PORTLAND MAINE

February 20, 2013

RE: 87-K-2, 87-K-8, & 87-K-29 Island Avenue & Pleasant Avenue, Peaks Island –
IR-2 Zone

min street frontage  
street problem of 7<sup>th</sup>  
approach on this one  
Option A.

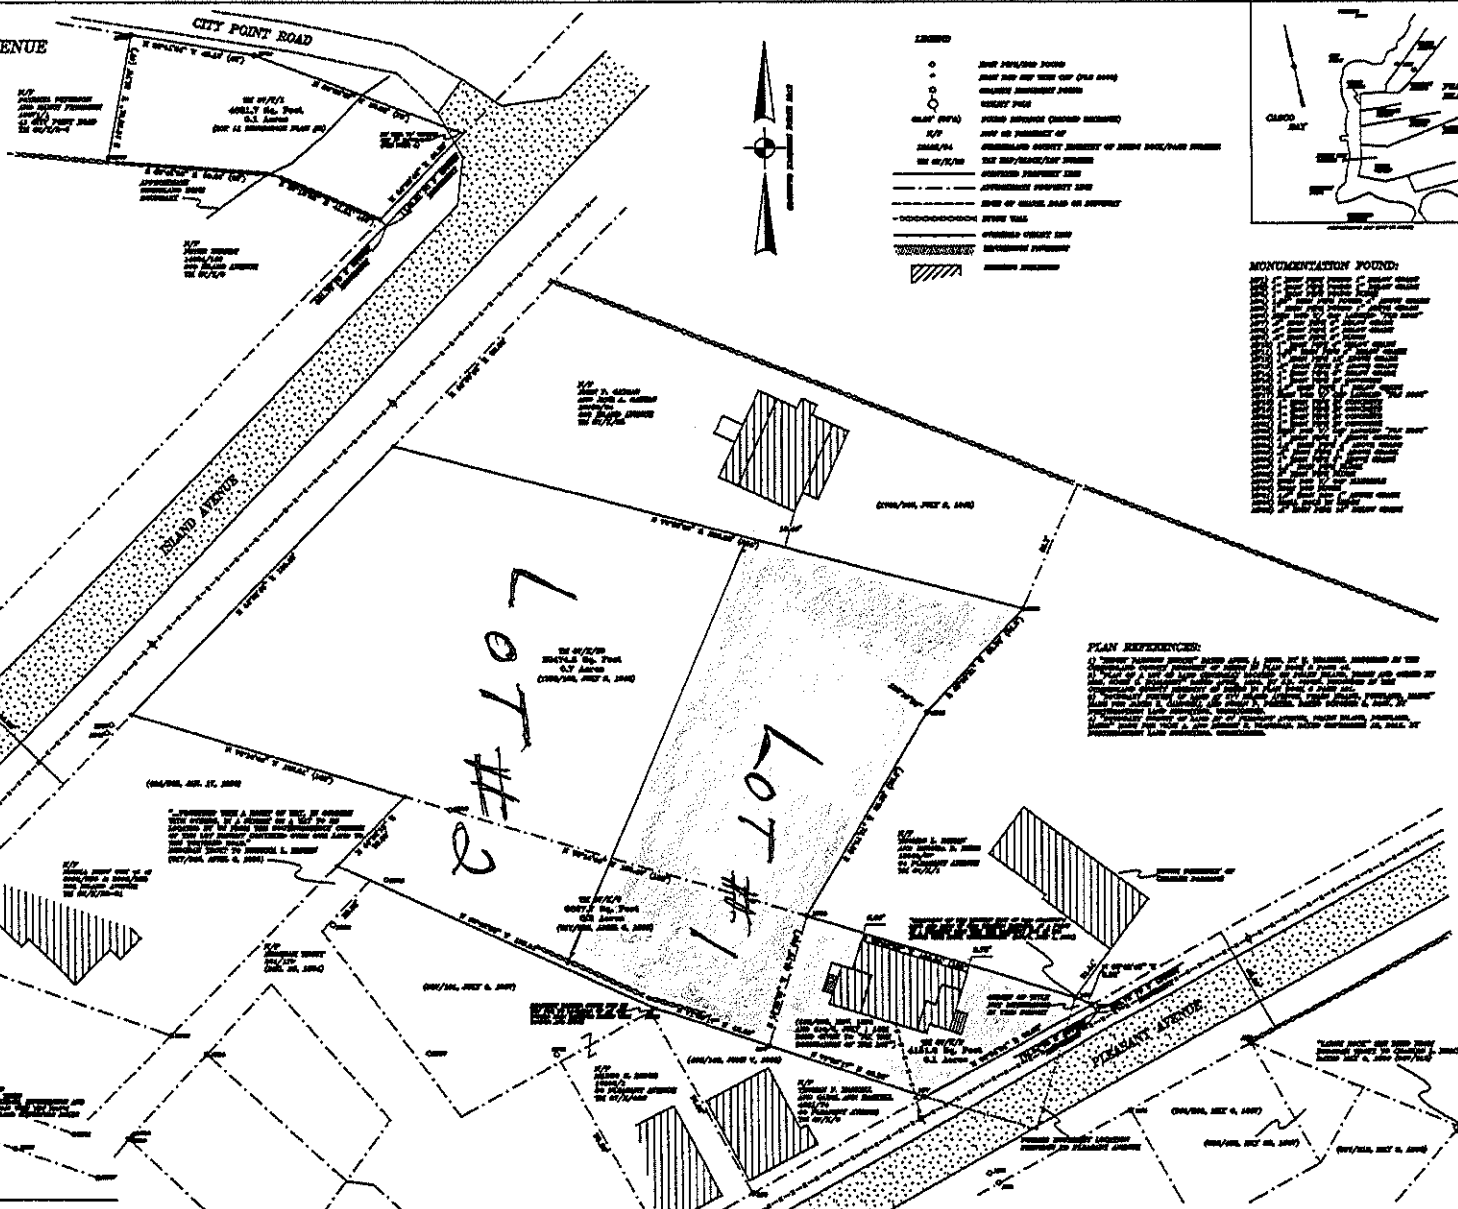
I have been given two reduced copies of the survey each suggesting a different division of land into two parcels. Based upon the IR-2 zoning requirements, option "A" would not meet the underlying zone requirements requiring 70 foot of street frontage [section 14-145.11(b)]. Please note that section 14-422 does not permit the division of land if any lot shall be so reduced that yards, lot width, *lot frontage*, lot area, area per dwelling unit, and space for off-street parking and/or off-street loading shall be less than the minimum required under the Land Use Zoning Ordinance. Currently the one lot is meeting the minimum street frontage requirements using both Pleasant Avenue and Island Avenue as combined street frontage. It is agreed that either division of land options will not affect the current legal nonconformity of the existing single family dwelling for the northern side setback, for the minimum lot width, or for the minimum front setback.

# Gulliver Property - Peaks Proposed Lot Split Option B

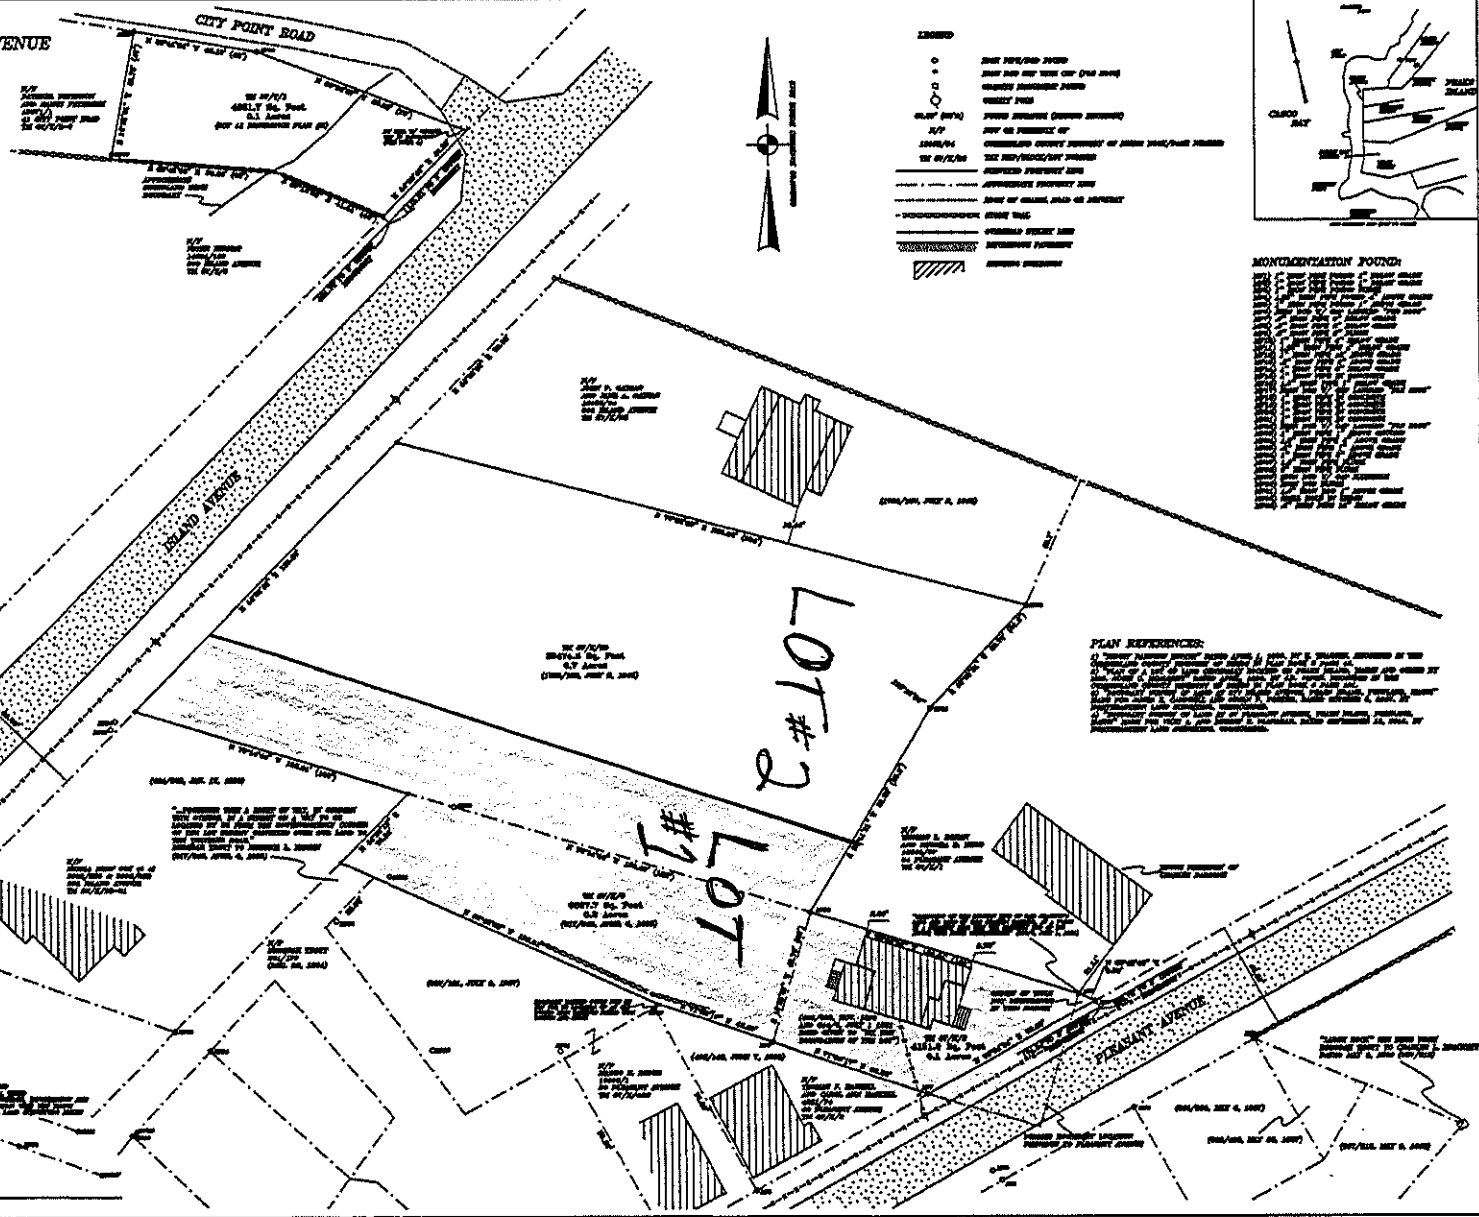
Therefore, at this time before a formal division of land is completed with a survey, the concept of option "B" appears to better meet the Land Use Zoning Ordinance and based upon the information given in your letter, would meet the requirements of the IR-2 zone.
